Location: Phynis Farm Catlow Road Slaidburn BB7 3AQ

Proposal: Approval of details reserved by conditions 3 (materials), 4 (windows and doors frames), 5 (window and door cills/lintels), 9 (boundary treatments), 10 (external lighting), 14 (bird/bat boxes), 20 (cycle storage) and 21 (historic building record) on planning permission 3/2023/0056.

The Local Highway Authority have the following comments to make based on all the information provided by the applicant to date.

Document Date:
01/06/2026
Document Stage:
PLANNING
Drawn By: RH
Checked By: RH
Sheet Name:
PROPOSED CYCLE STORAGE PLAN

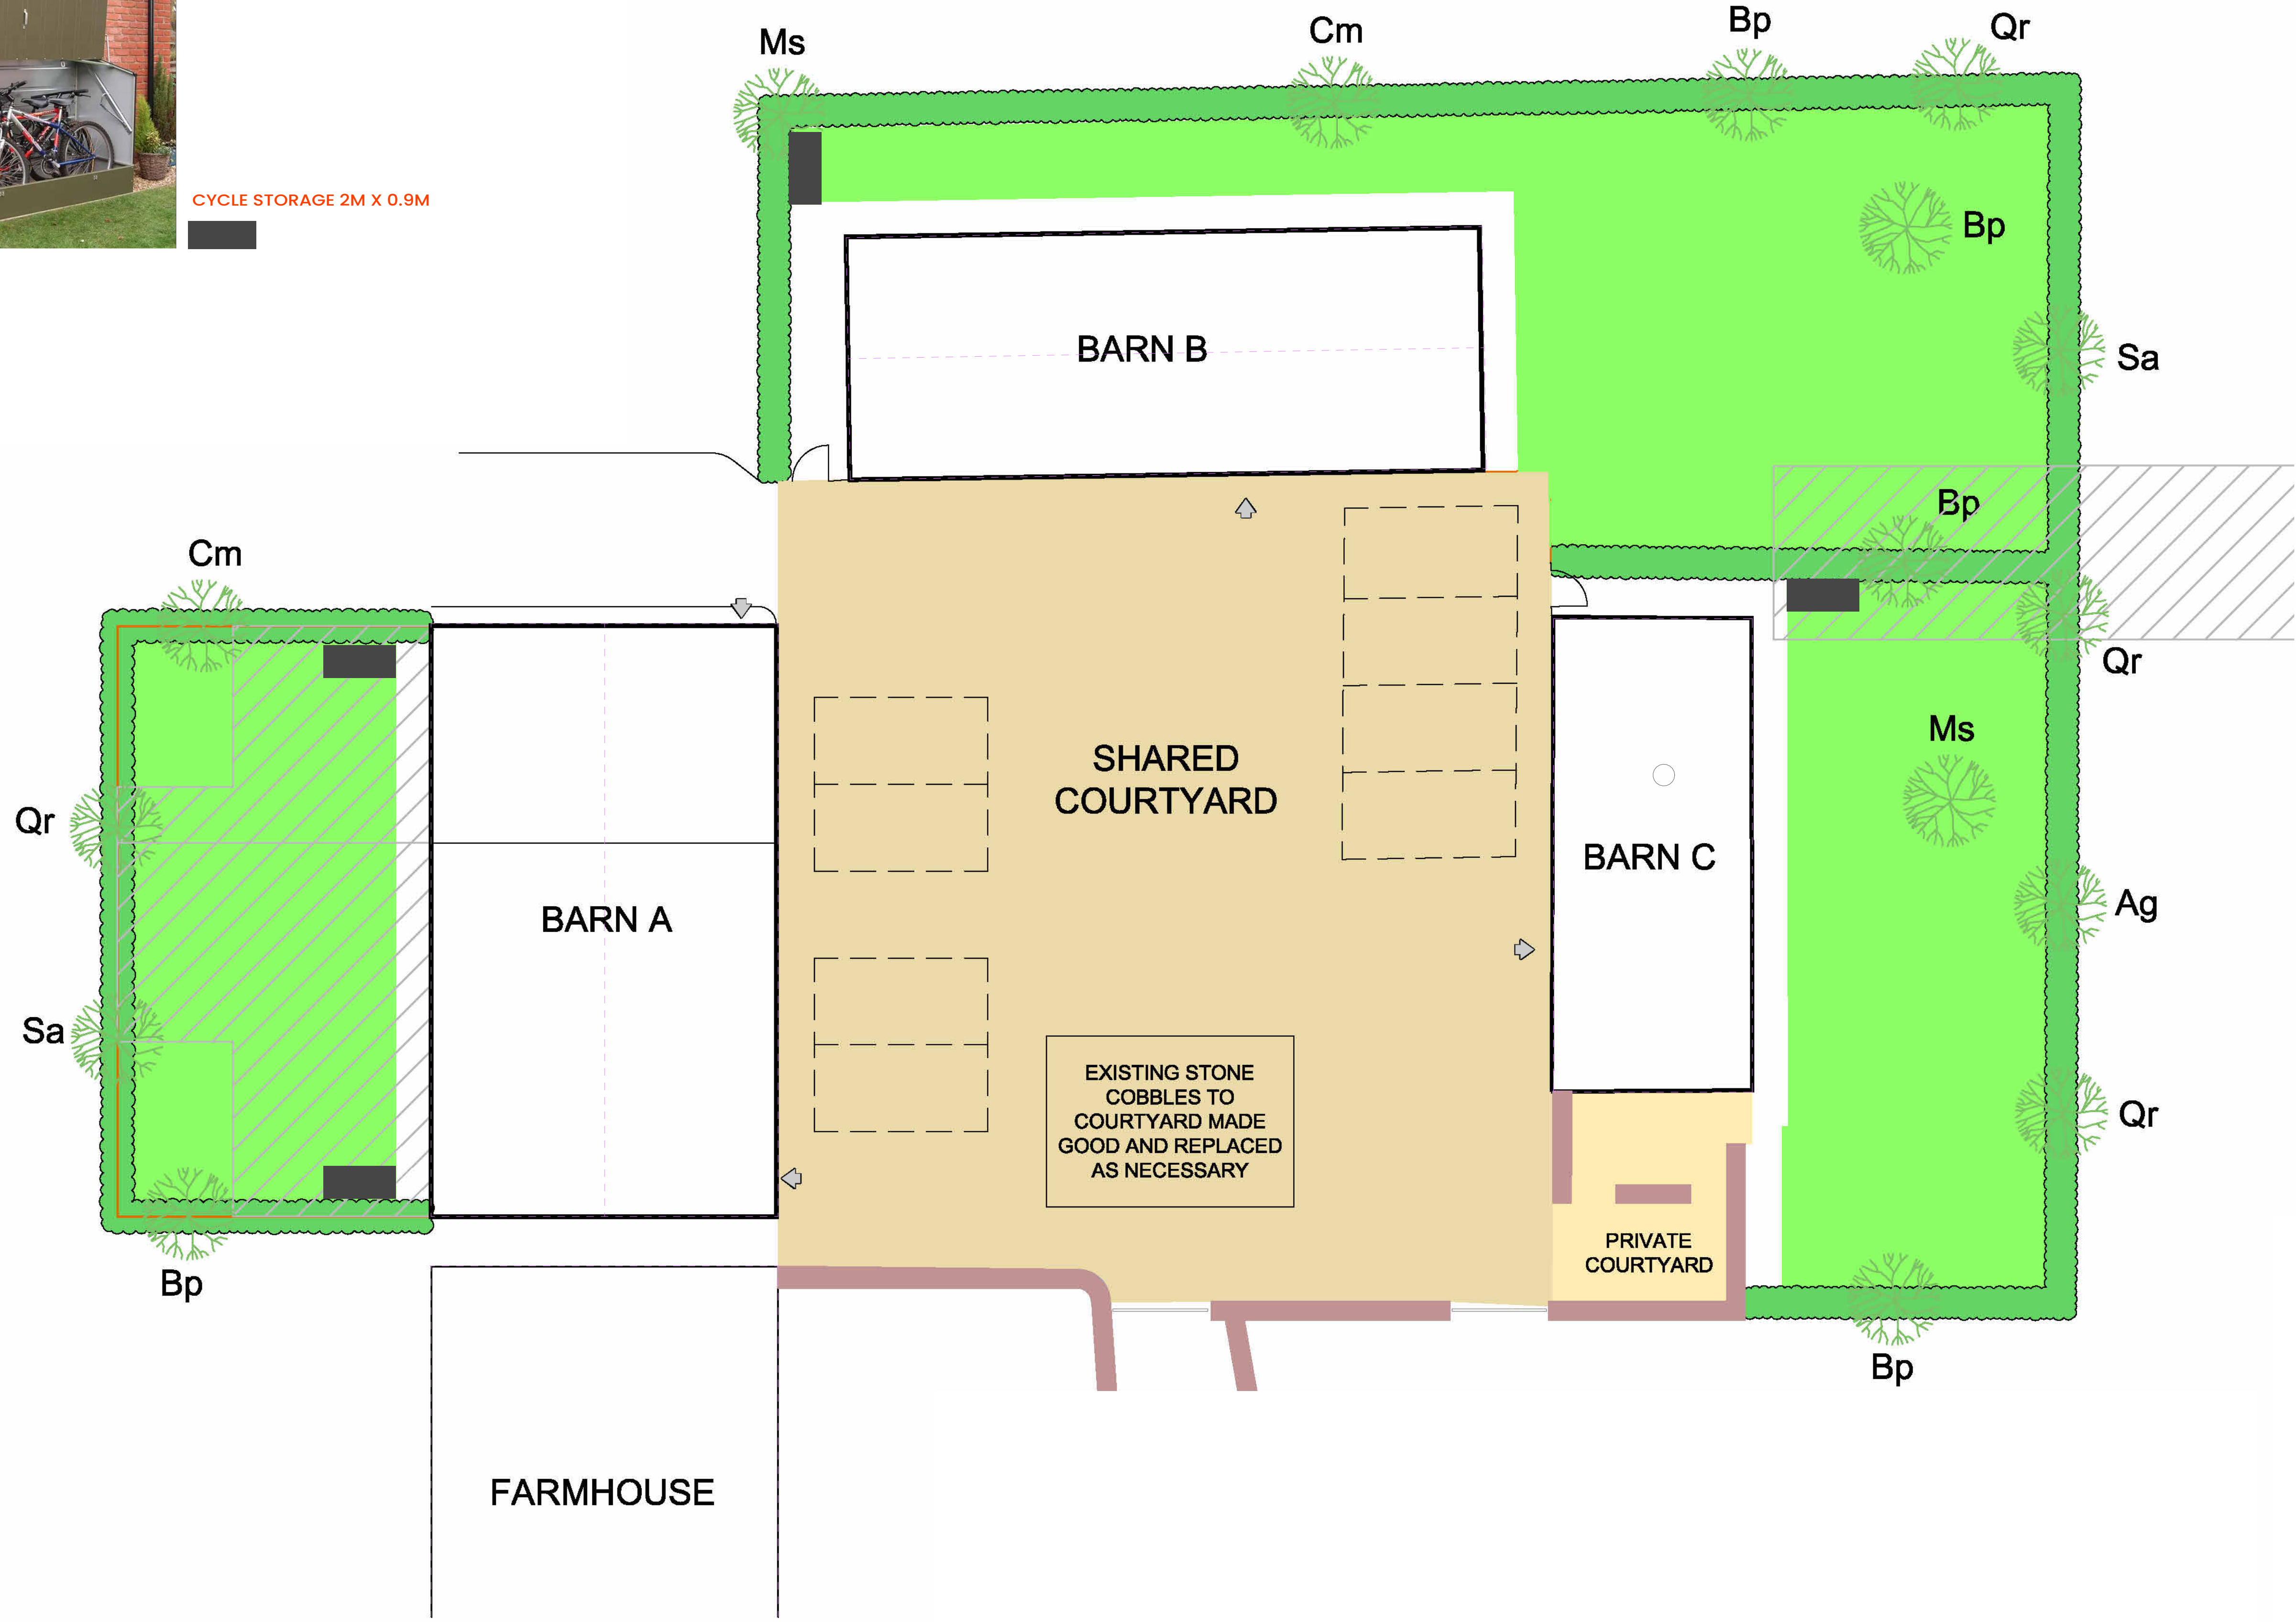
The Highway Development Control Section of Lancashire County Council has no objections to the approval of details reserved by condition 20 and is satisfied with the information provided within the proposed cycle storage plan, drawing PL4.05.
